# **OXFORDSHIRE COUNTY COUNCIL'S RESPONSE TO CONSULTATION ON THE FOLLOWING DEVELOPMENT PROPOSAL**

**Application no:** 15/01068/F-2

**Proposal:** Erection of two storey extension to existing hotel to form 62 new bedrooms (60 net increase)

## **Transport**

Drawing Title:
 Pond & discharge detail

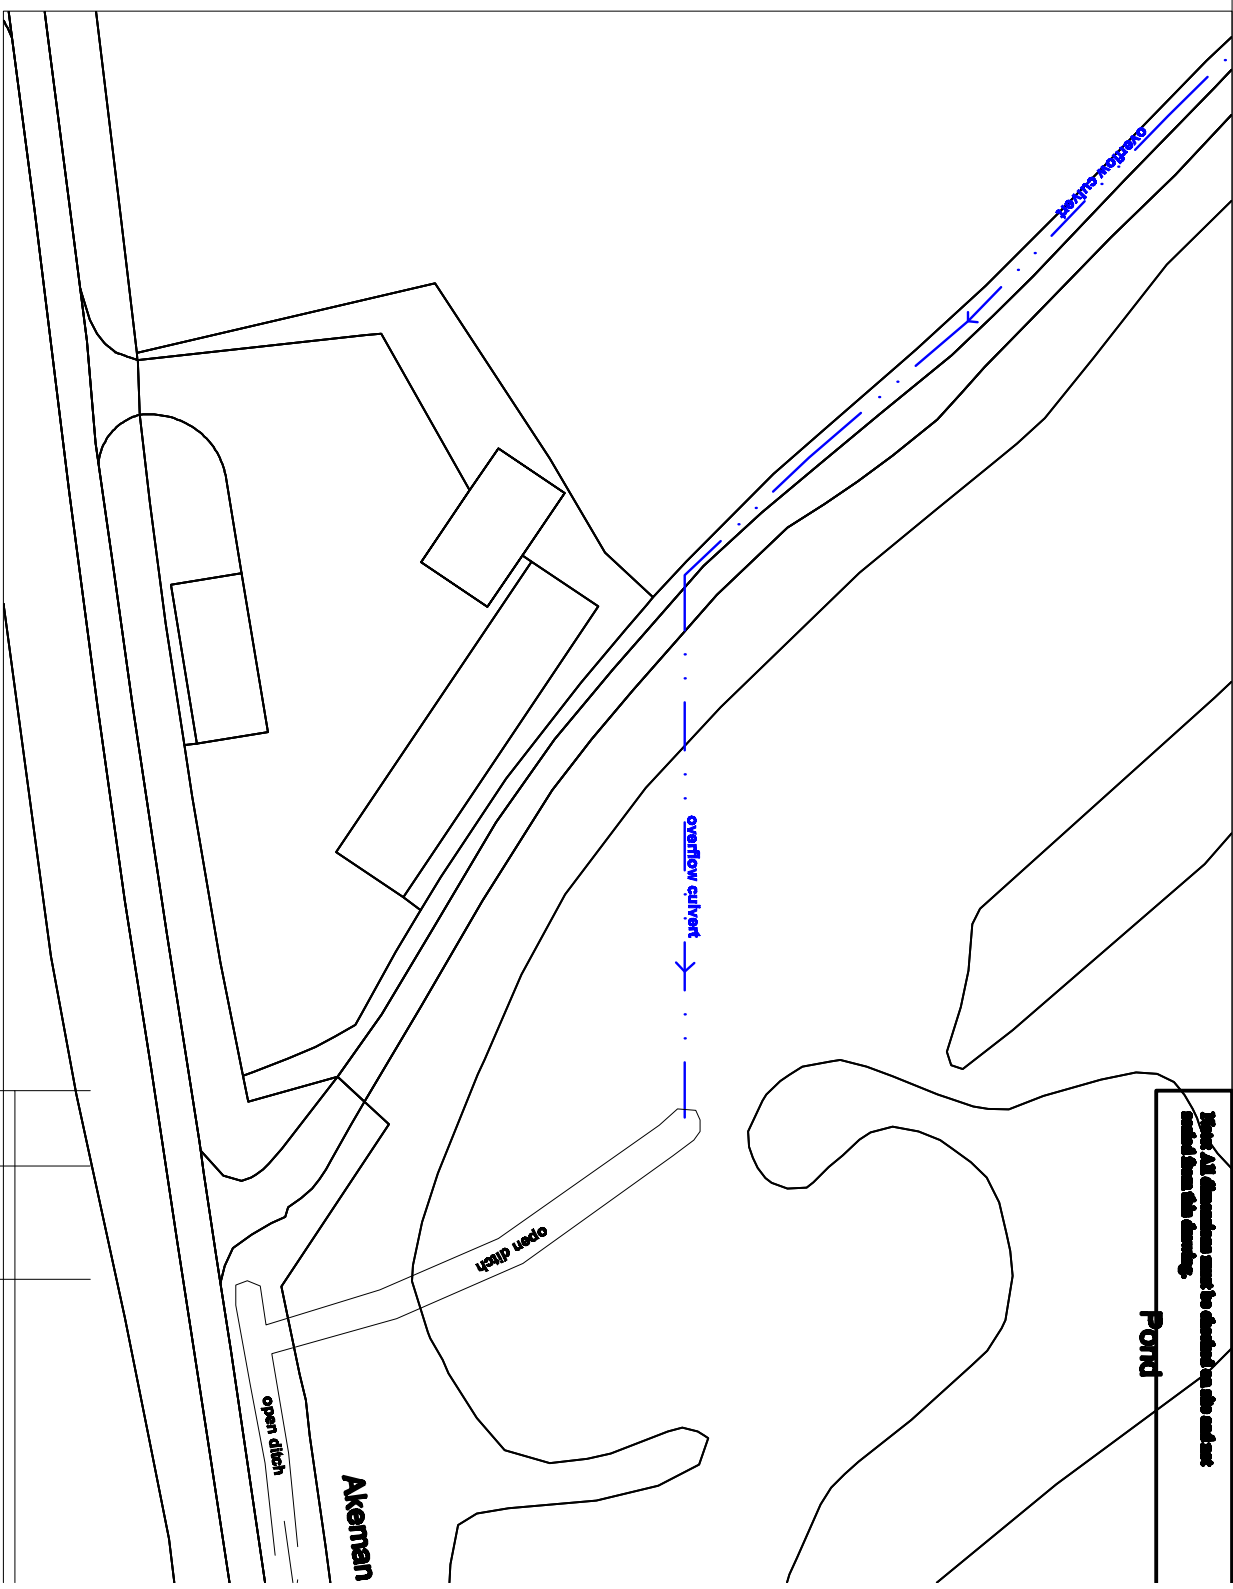
- The plan shows no drainage of the hotel extension
- It only shows an overflow from the pond
- As this is a new overflow, which connects to a ditch the applicant will need to apply to OCC for consent supplying expected discharge volume.
